**Consultation Response from KC,  
Highways Development Management**

**2023/91261 land at, Alexandra Road West, Paddock, Huddersfield, HD3 4EX**

**Erection of two detached dwellings with garages, regrading of land and erection of retaining walls to form access and turning area from Lower Gate**

**Date Responded: 26/07/2023.**

Scale: @ A1  
**1:100**  
Date  
**Apr '23**  
Drawing no  
**20.1127/(AL)40**  
Drawn by  
**CG**  
App'd  
**-**  
Rev  
**A**

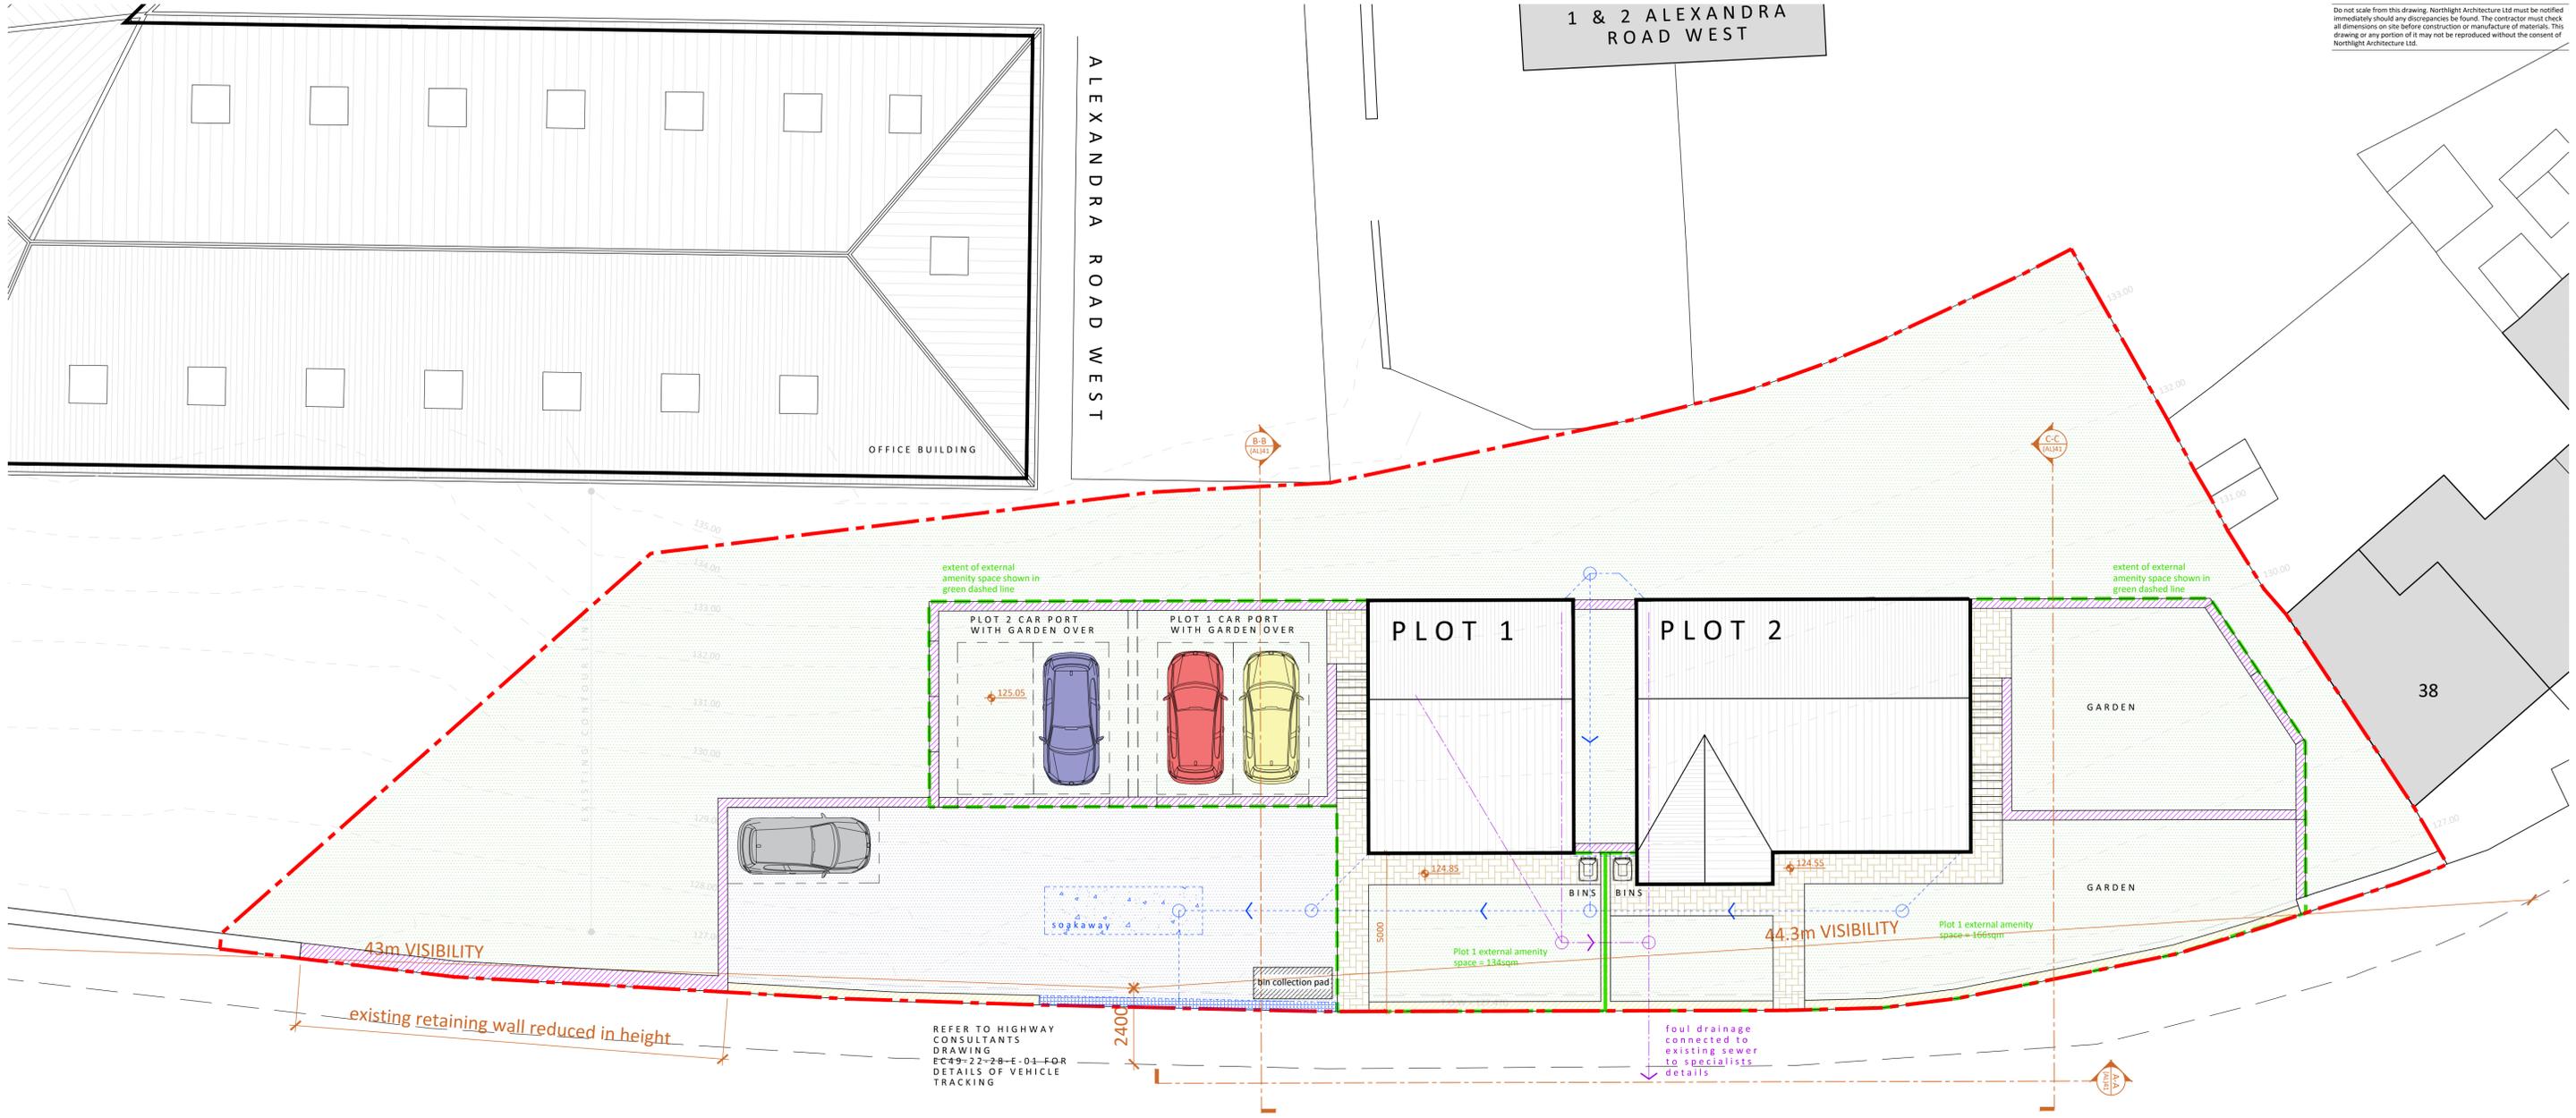
- A revised layout showing a widened access and the location of the proposed parking spaces serving the dwellings together with a swept path analysis to show that these vehicles can turn to leave the site in forward gear needs to be provided.
- Details of waste storage and collection for both dwellings should be provided, with the location of a waste collection presentation point being clearly marked on a drawing.

The width of the dropped kerb crossing should be based on the swept path analysis and should be wide enough to make a turn in to the site easy and thus reduce the amount of time a vehicle will have to obstruct the adopted highway whilst entering the site, as due to the TRO markings, overtaking is not allowed at this location.

The minimum width should allow two vehicles to be able to pass one another.

Scale: @ A1	Drawn by
1:100	CG
Date	App'd
Apr '23	-
Drawing no	Rev
20.1127/(AL)40	B

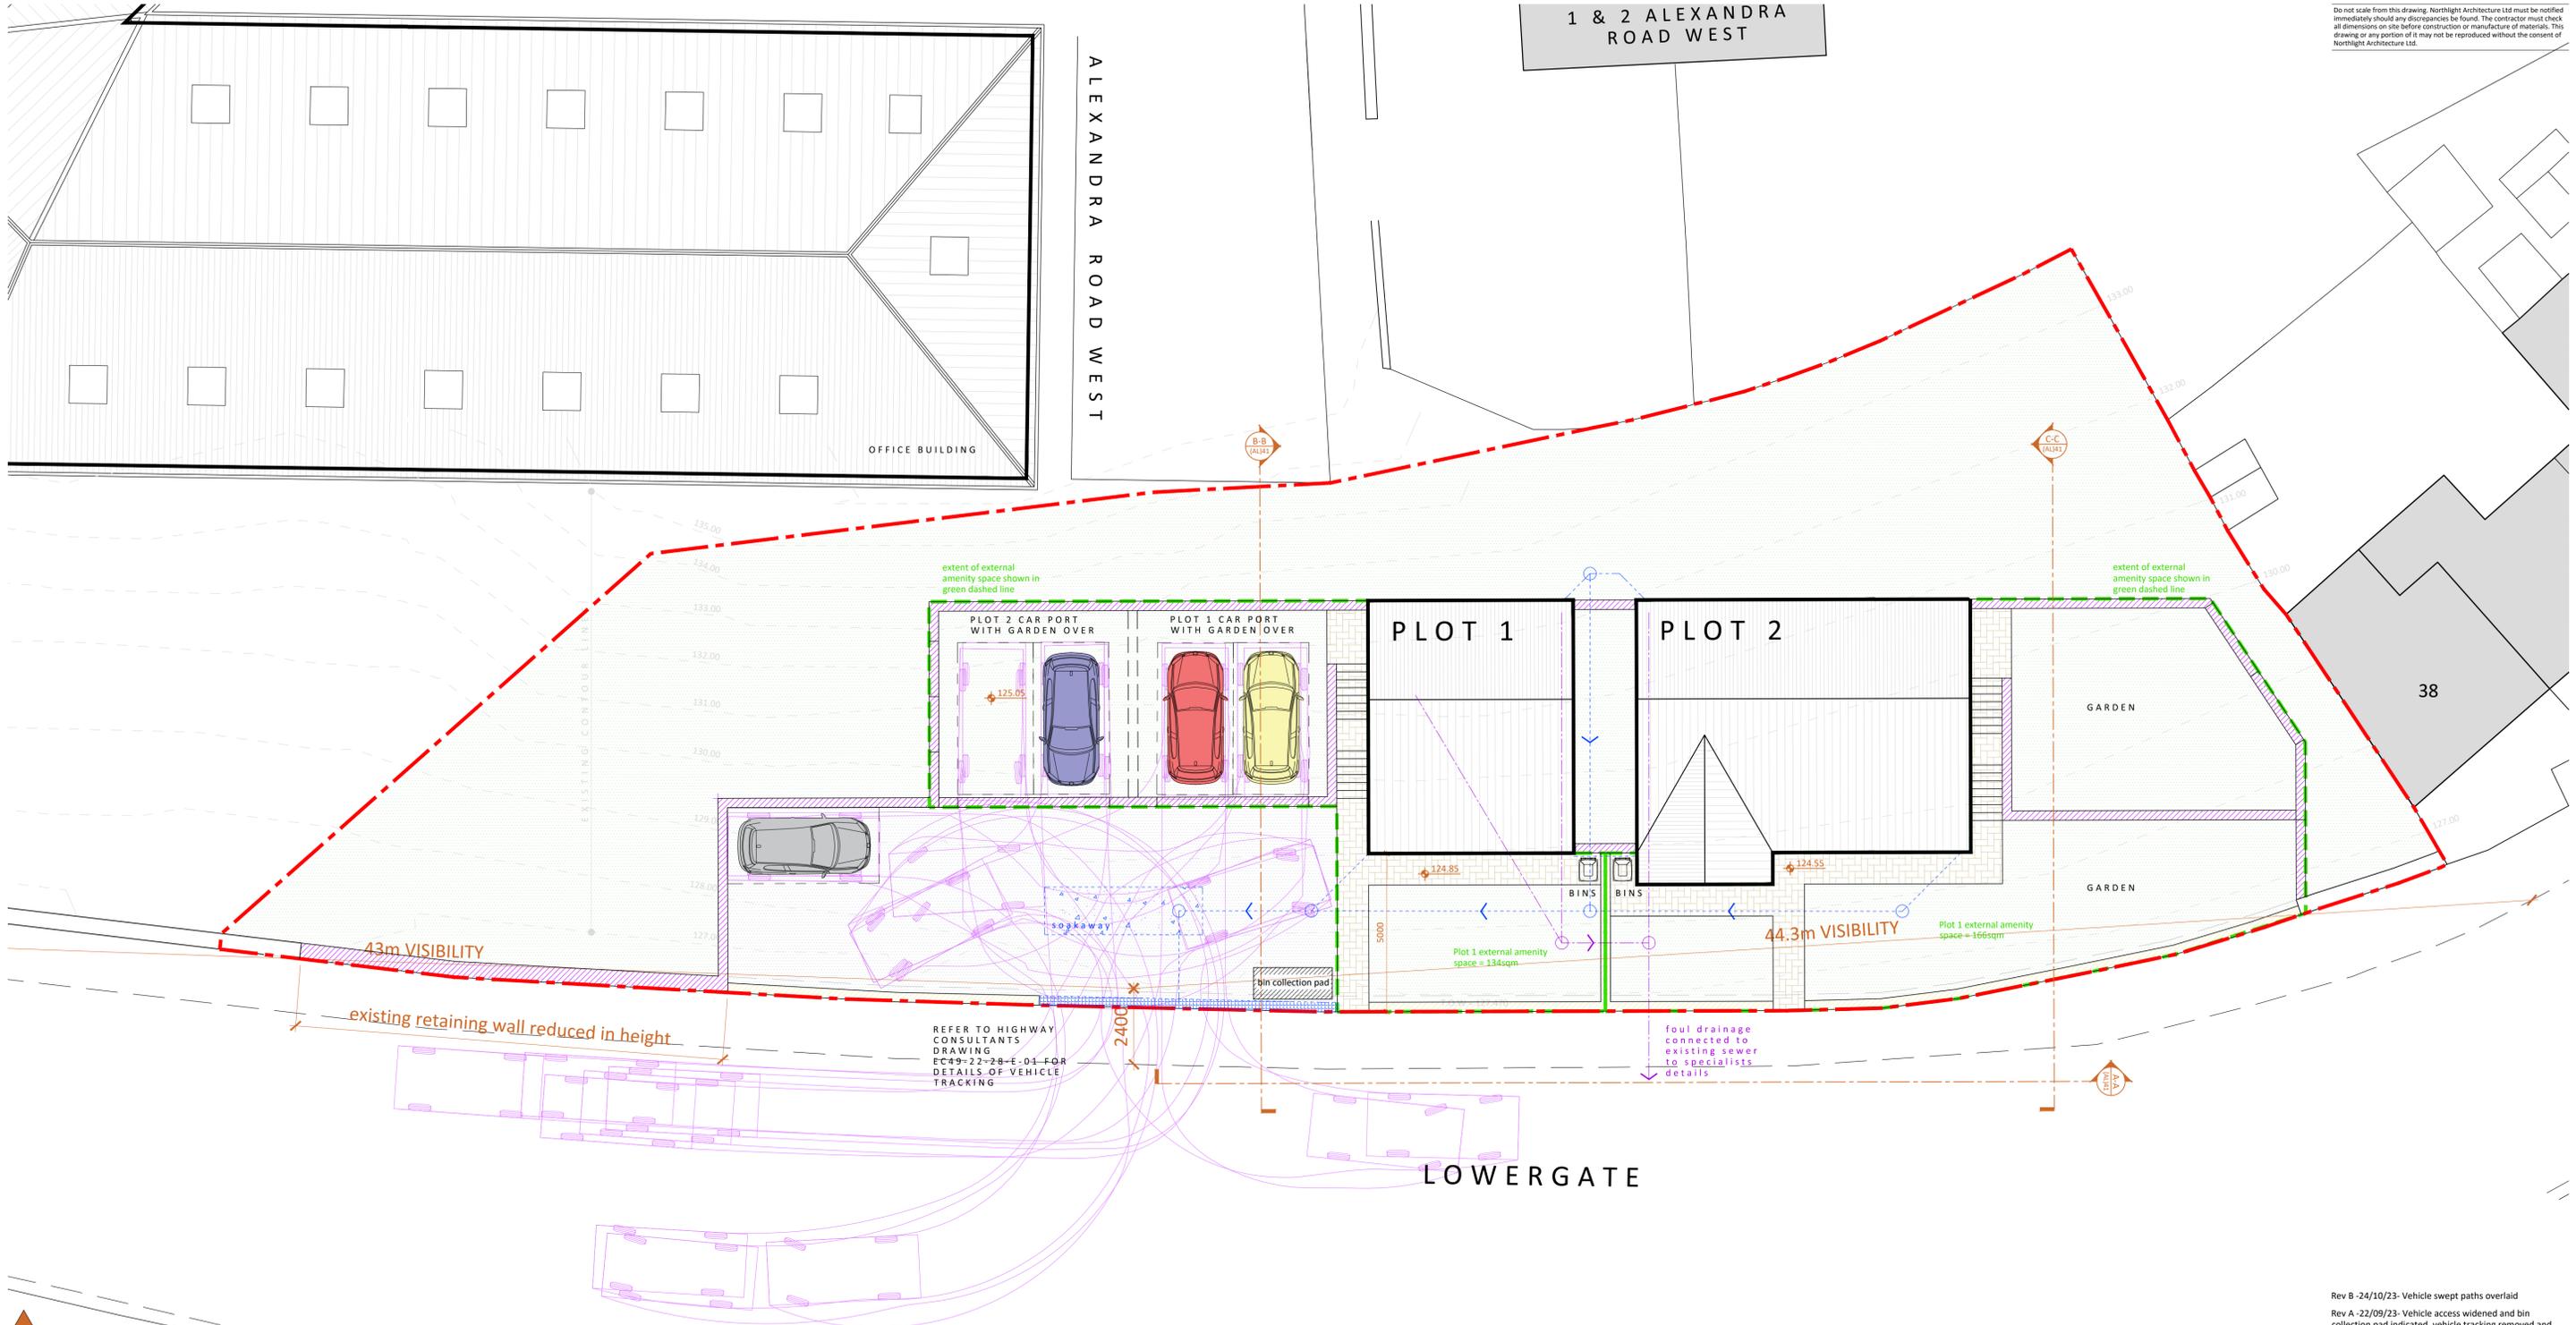
The applicant should provide a swept path analysis to show that all parking spaces can be accessed/egressed in forward gear from the highway.

Scale: @ A1	Drawn by
1:100	CG
Date	App'd
Apr '23	-
Drawing no	Rev
20.1127/(AL)40	-

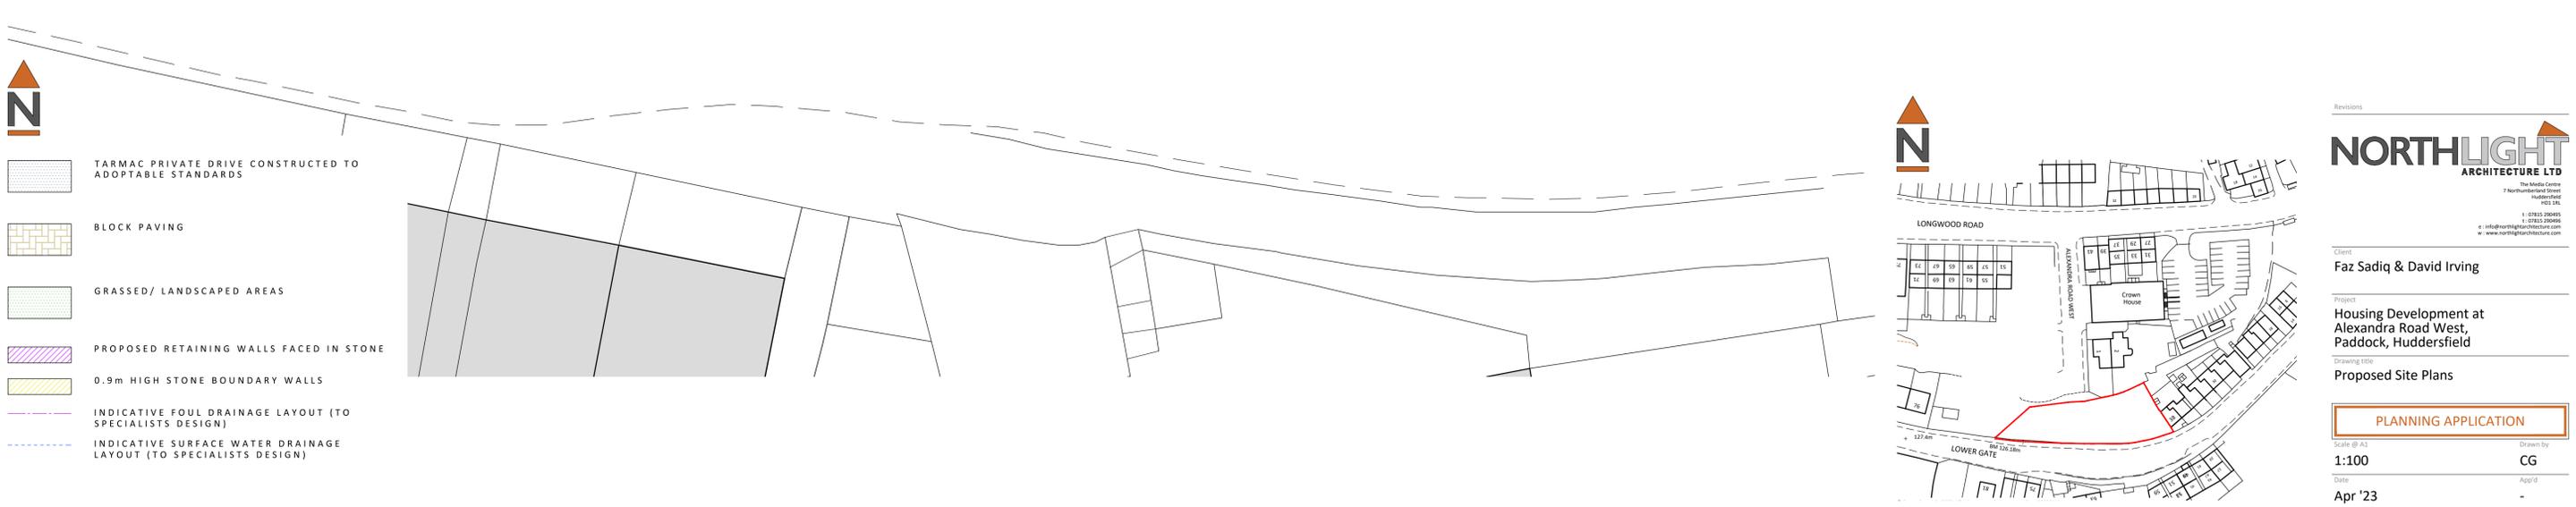
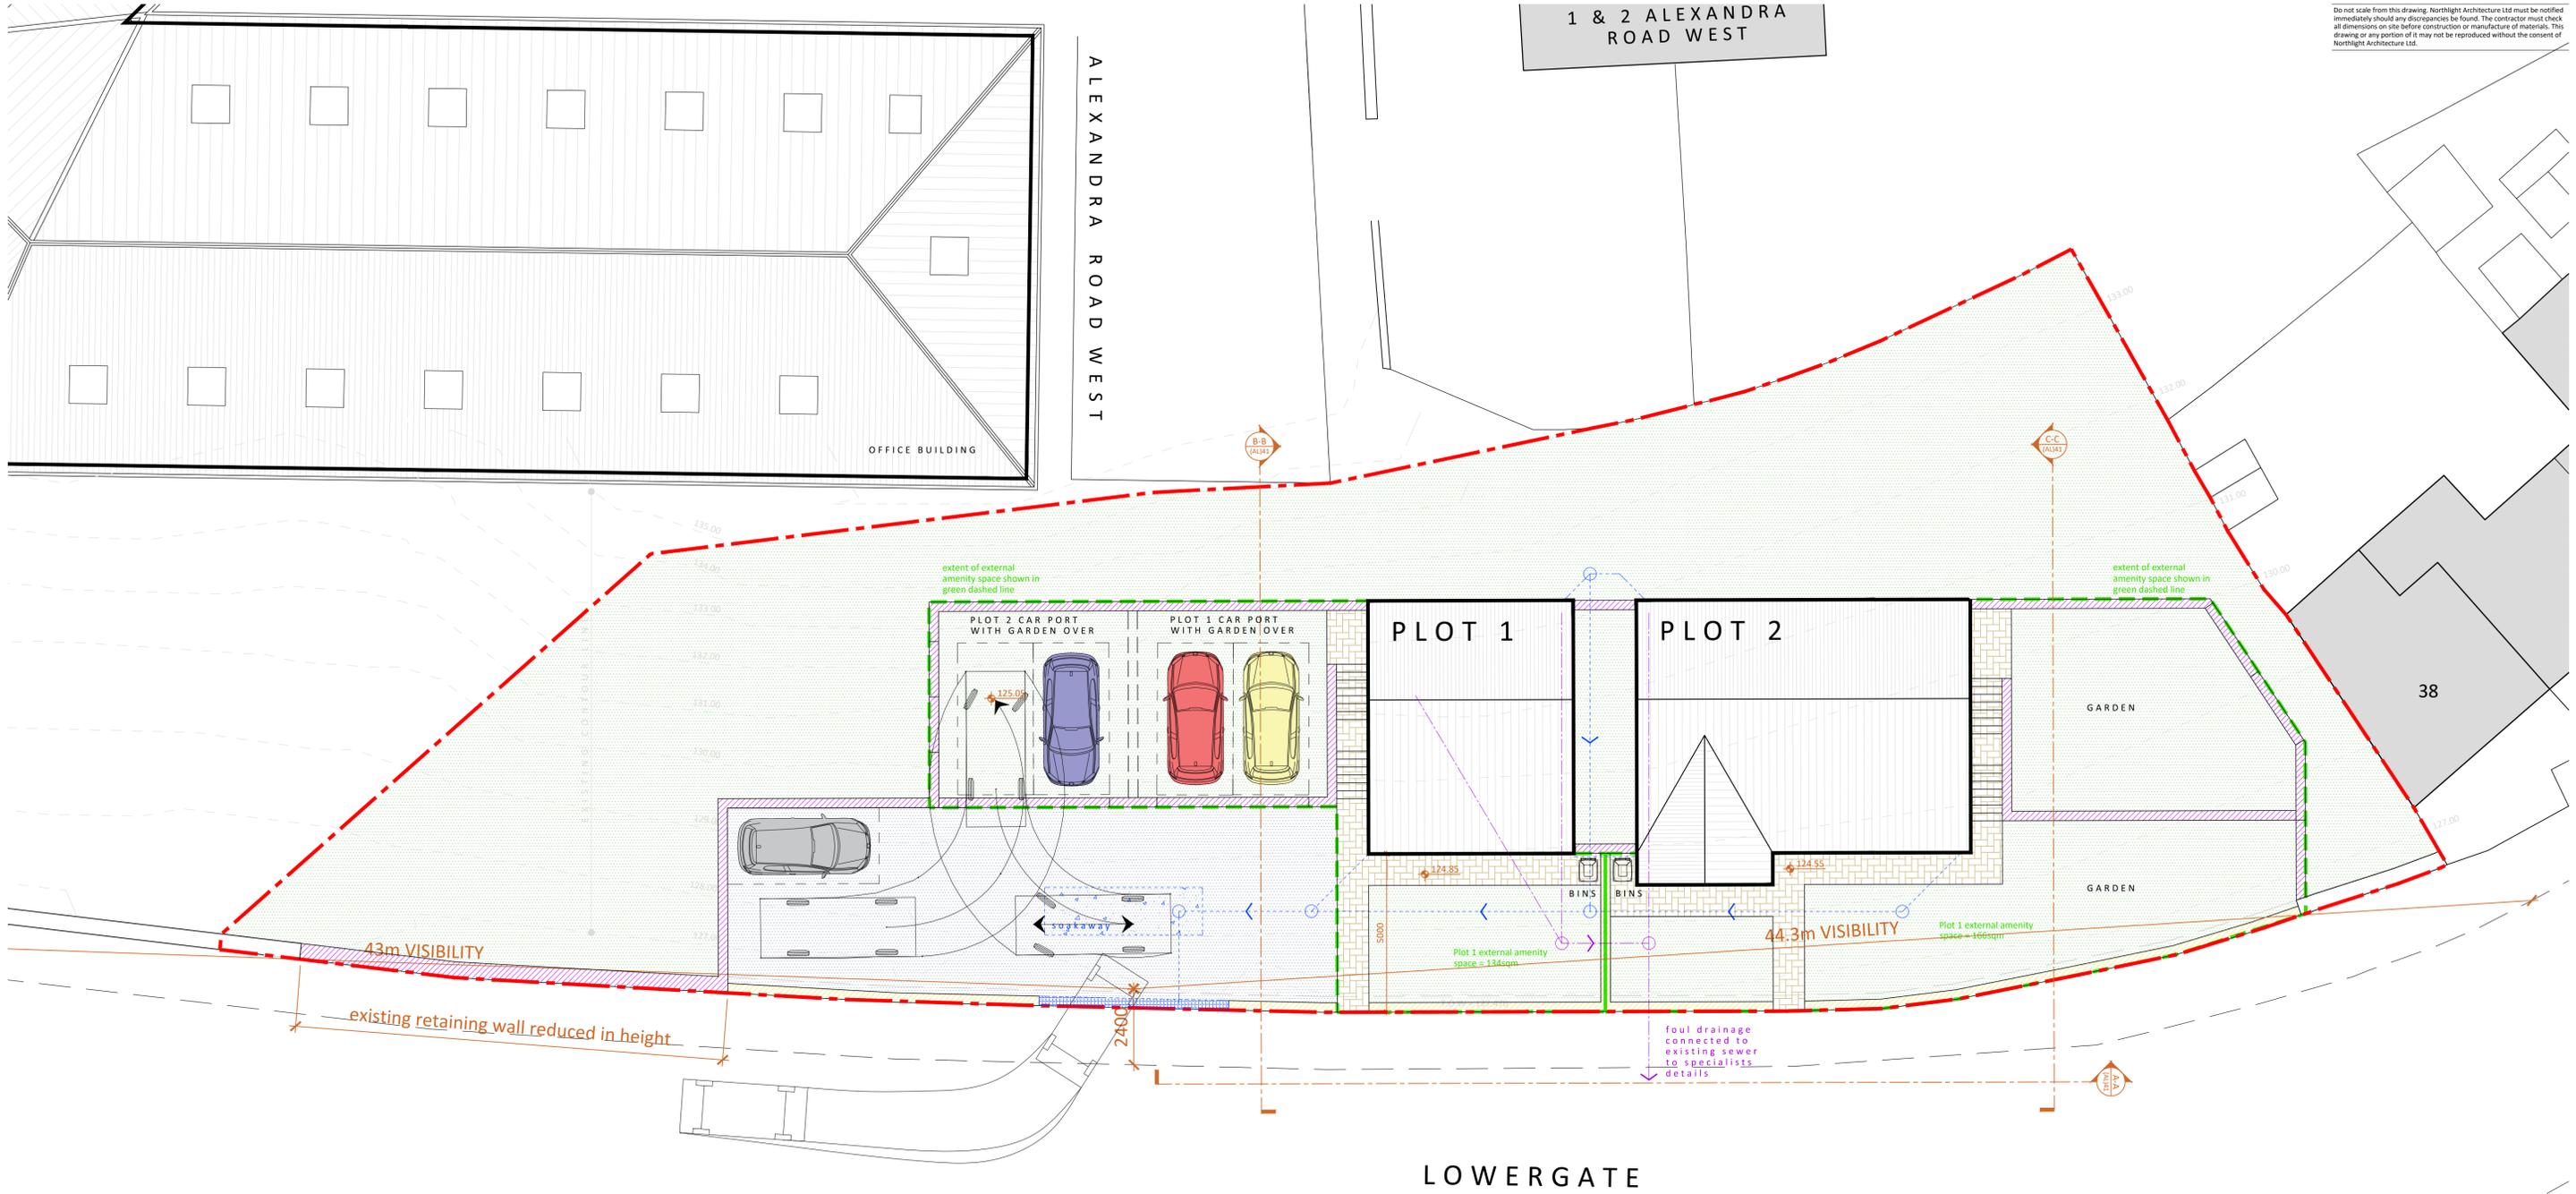
Drawing No 20.1127/(AL)40 shows 43m visibility splays can be achieved from the proposed access.

The visibility splay to the left is achievable over the front garden of the proposed dwellings and because of this we would like to see nothing permitted to be above 0.9m high within the visibility splay and this should be conditioned.

Drawing No 20.1127/(AL)40 shows 5 parking spaces comprising 4 located within two car ports and one driveway space.

The two car ports have internal dimensions of 6m x 6m and these would be acceptable for four parking spaces and the driveway parking is also acceptable in size.

However, the layout does not provide sufficient turning space within the car park to make all these spaces easily accessible.

The swept path provided, which is meant to show indicative vehicle turning within the site actually shows that vehicles are not able to turn within the site if the neighbouring spaces are occupied.

This may require the parking layout to be redesigned to achieve this.

The sightlines of 2.4m x 43m along Lowergate, as shown on the approved plan, shall be cleared of all obstructions to visibility exceeding 0.9 m in height and these shall be retained free of any such obstruction throughout the lifetime of the development. Reason: To ensure adequate visibility in the interests of highway safety

Notwithstanding the details shown on the approved plan, no development shall take place until a scheme detailing arrangements and specification for layout of parking including a swept path analysis showing safe turning space has been submitted to and approved in writing by the Local Planning Authority. Before any building is occupied the development shall be completed in accordance with the details shown on the approved plans and retained thereafter. Reason: To ensure a suitable access and layout in the interests of highway safety
